Graeme Thorpe,
Planning Department,
Ribble Valley Borough Council

Ecological comments
Planning Application No: 03/11/0417
Proposals: Annex Building
Location: Clerk Laithe Barn
District: Ribble Valley

John Jones
Ecologist
Lancashire County Council

S.J. Bialacki Limited Building Surveyors
Drawing no 5006
Scale 1:100
Proposed Site Layout
Proposed Annex Extension At Clerk Laithe Barn Newton in Bowland

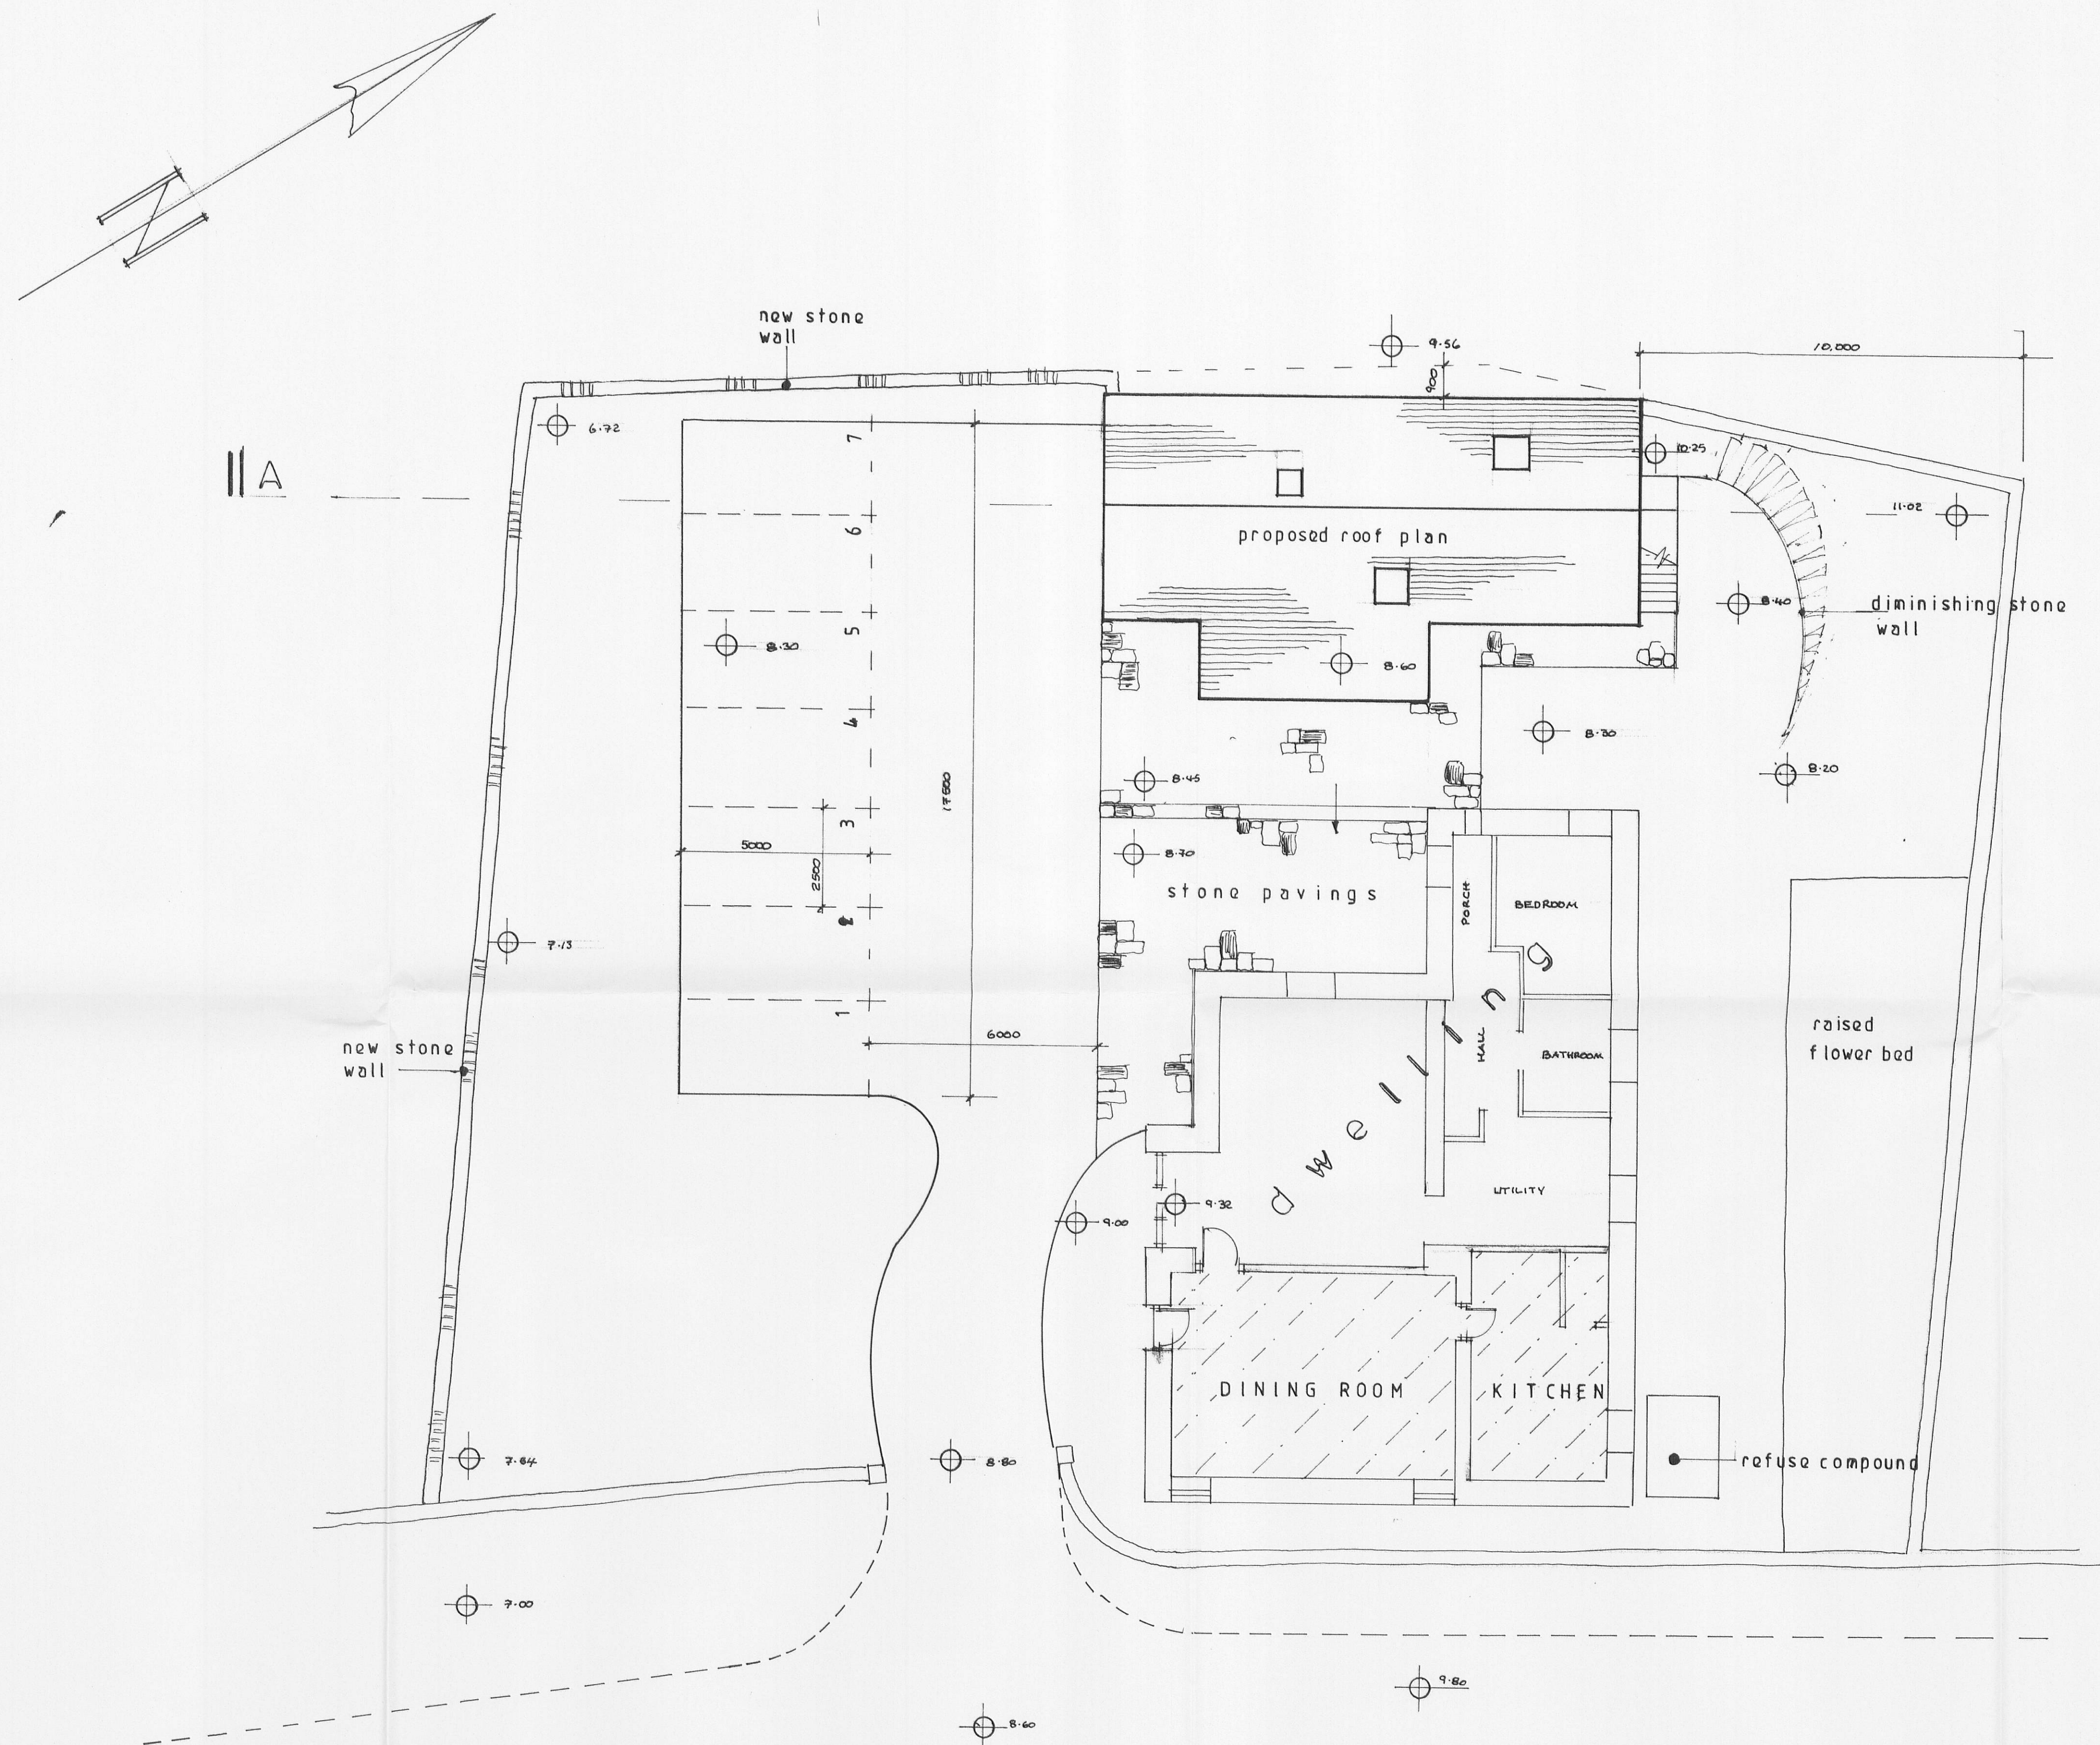
- Any works that may affect nesting birds will be avoided between March and August inclusive, unless the absence of nesting birds has been confirmed by further surveys or inspections.
- Working methods shall ensure that impacts on Newton North Roadside Verges Biological Heritage Site (BHS 65SE06) are avoided (for example damage resulting from vehicle movements or storage of materials).

The application area is immediately adjacent to Newton North Roadside Verges Biological Heritage Site (BHS 65SE06). Whilst the footprint of the development does not impinge on these verges, they could potentially be damaged by vehicle movements or storage of materials. A planning condition is therefore recommended to ensure that such damage is avoided.
